BENT GRASS EAST COMMERCIAL FILING NO. 2B

AN AMENDMENT OF TRACT B AND LOT 3 AS PLATTED IN BENT GRASS EAST COMMERCIAL FILING NO. 2 RECORDED UNDER RECEPTION NO. 214713515
RECORDS OF EL PASO COUNTY, COLORADO

BENT GRASS EAST COMMERCIAL FILING NO. 2B
JOB NO. 2177.61
APRIL 23, 2018
SHEET 1 OF 2

BENT GRASS EAST COMMERCIAL FILING NO. 2B
 JOB NO. 2177.61
 APRIL 23, 2018
 SHEET 1 OF 2

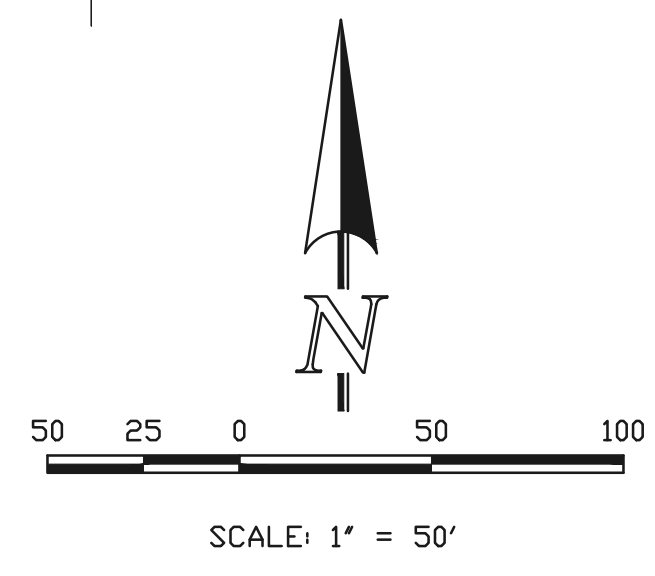
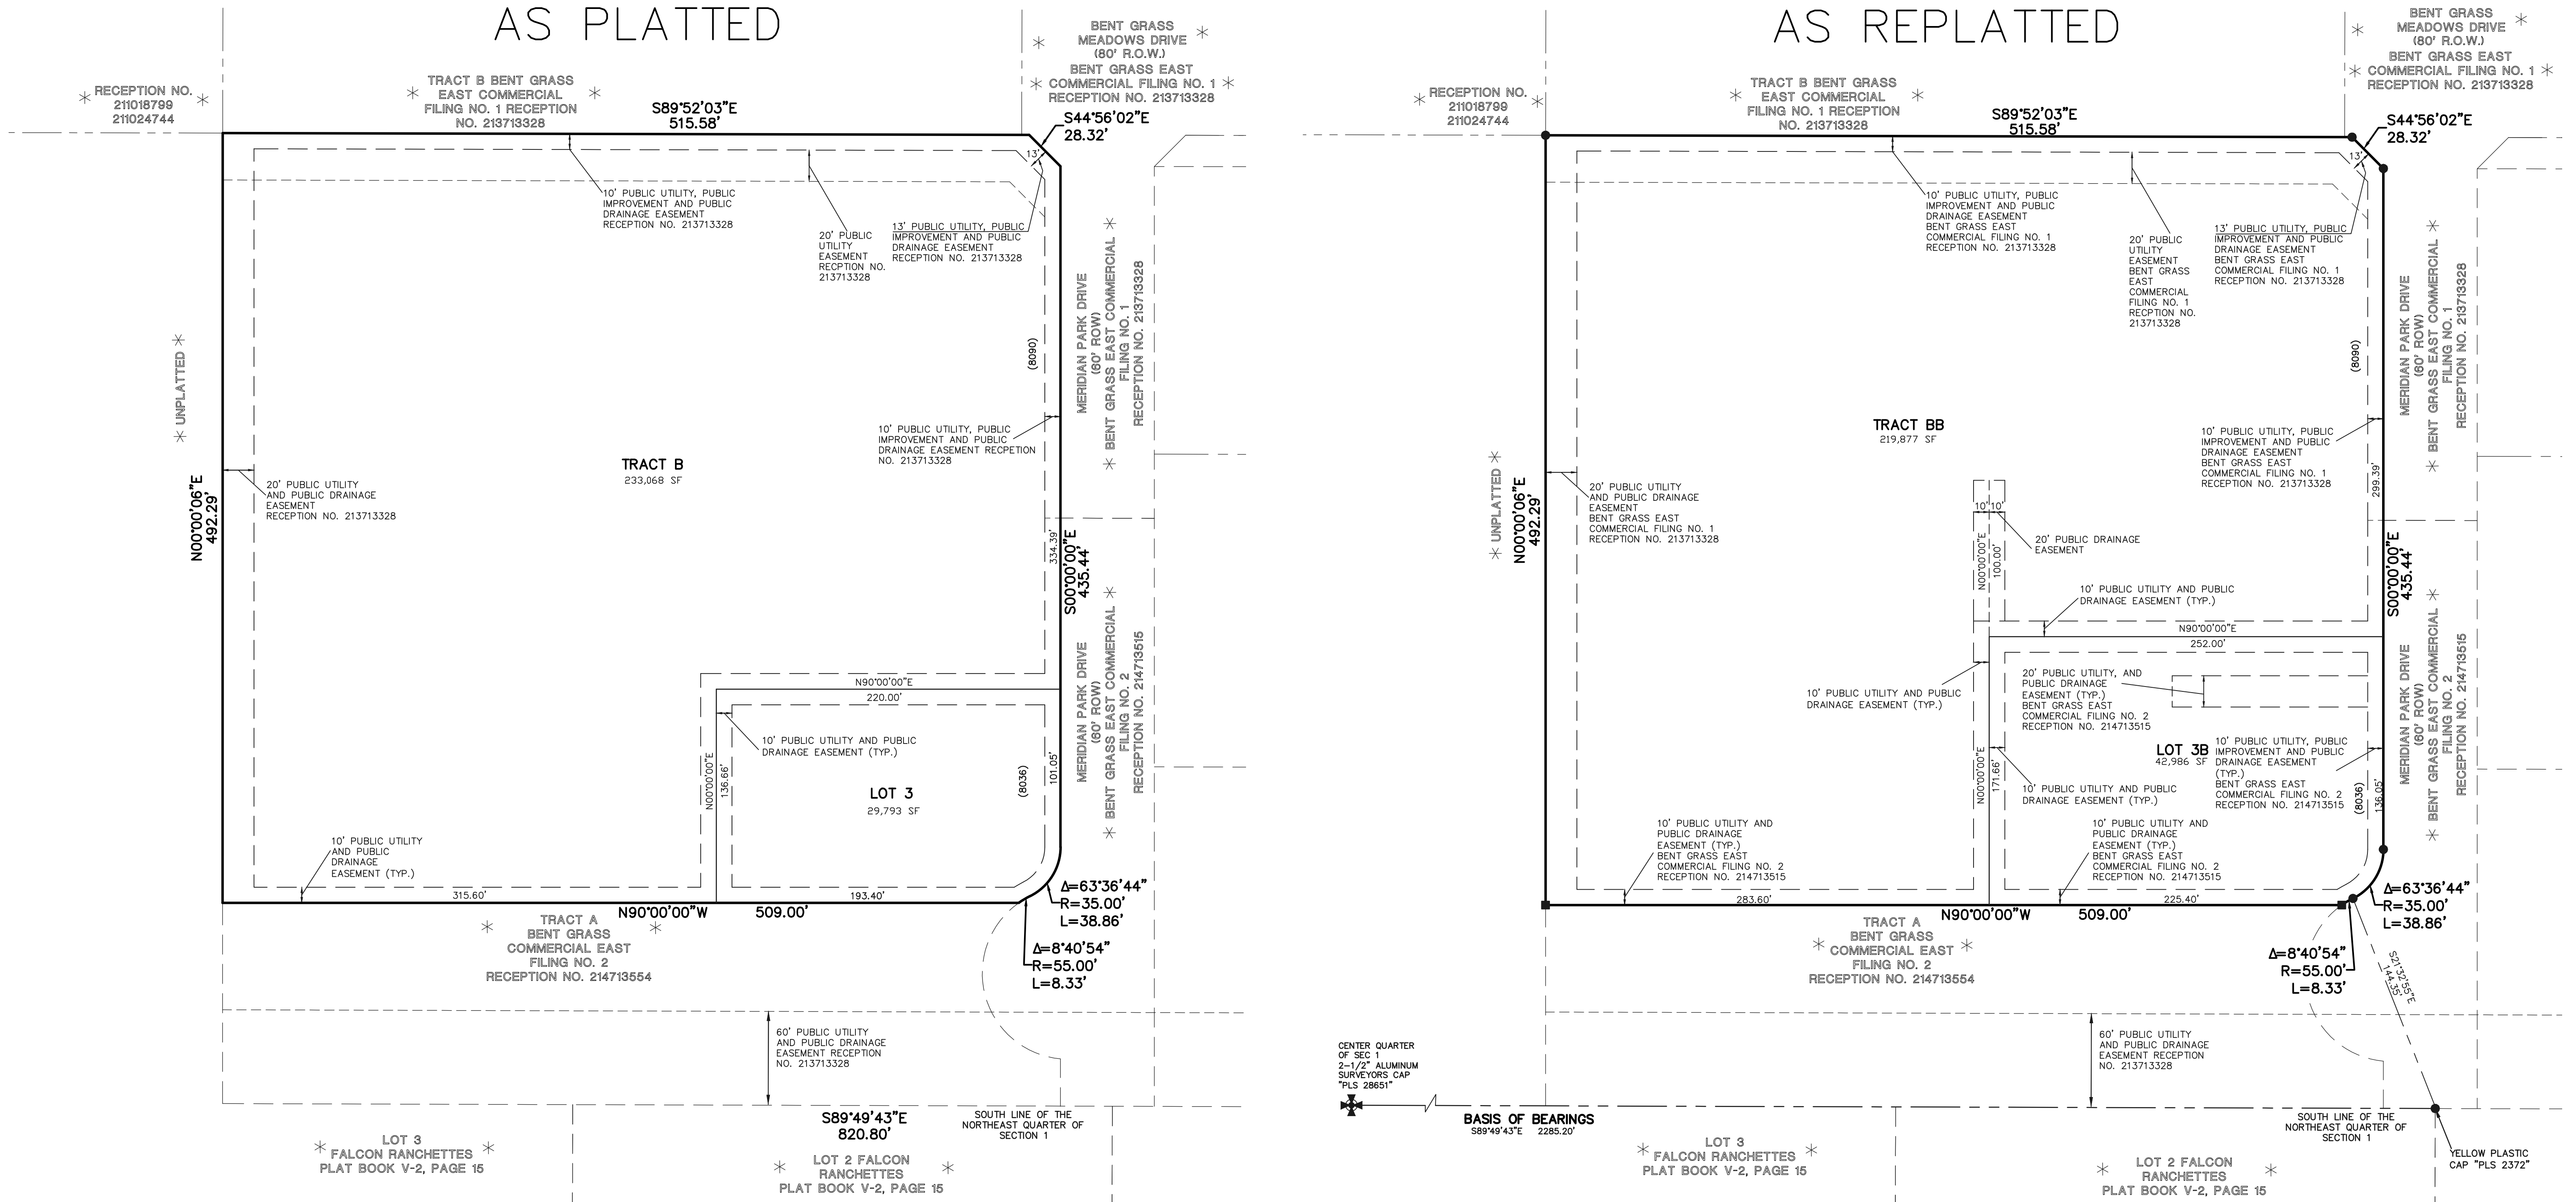
There are some easement & inclusions into taxing districts showing in the title work that need to be carried over to plat notes from title Commitment unless you want to graphically depict them. Also there are some dev agreements/SIA that also should be noted.

delete -no fees due for a plat amendment
